February 2, 2006

Patton's Point

Re: Status of Improvement Permit Application #06-5-13919 Lt 107
#06-5-13920 Lt 108
#06-5-13921 Lt 109

* House Plan: The Patton (Garage Right)

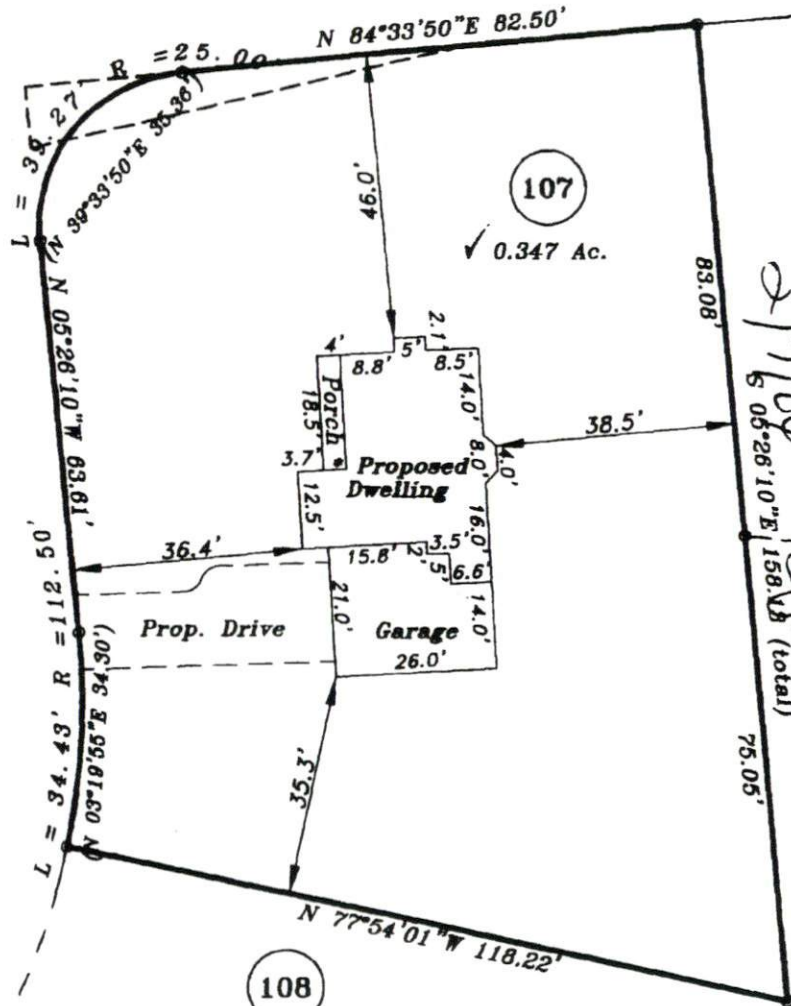
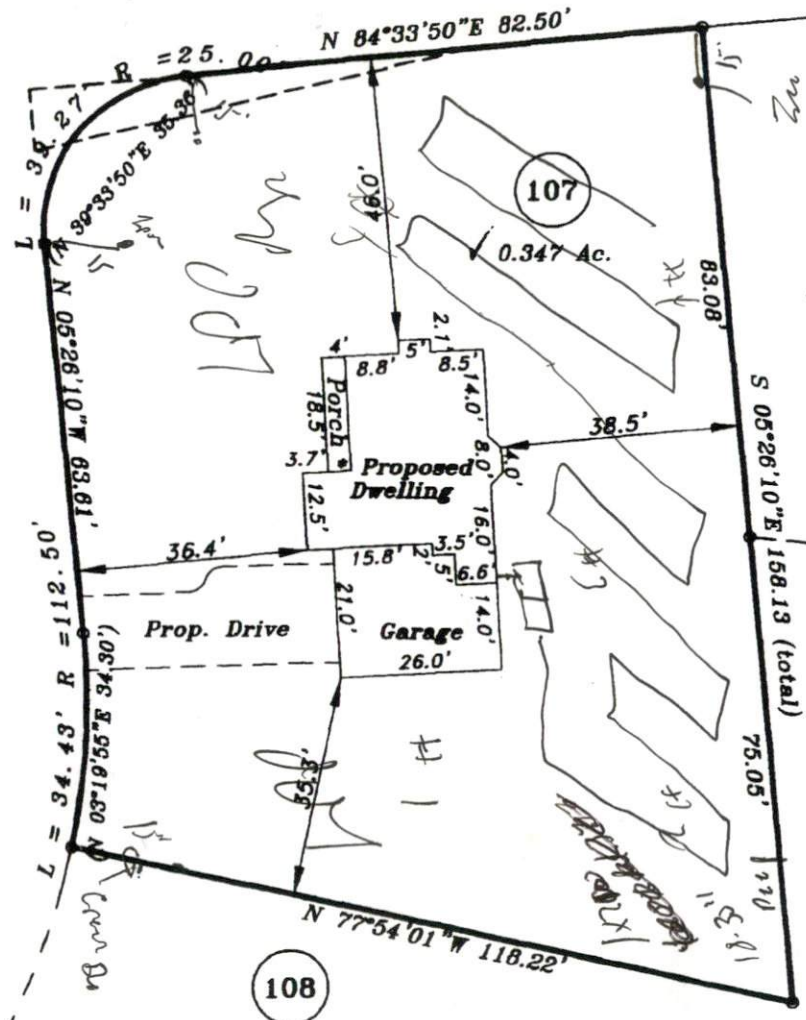
- 1. Property lines/corners not marked or labeled
- 2. House corners not marked or labeled
- 3. Directions not clear to property
- 4. Property needs brush or vegetation removed
- 5. Backhoe pits required
- 6. Other – **You have applied for 4 bedroom homes. Consultant letter states (see attached) for 3 bedrooms. I need lots 107,108,109 cleared so I can try to lay out systems for 4 bedrooms, or you can revise applications to 3 bedrooms.**
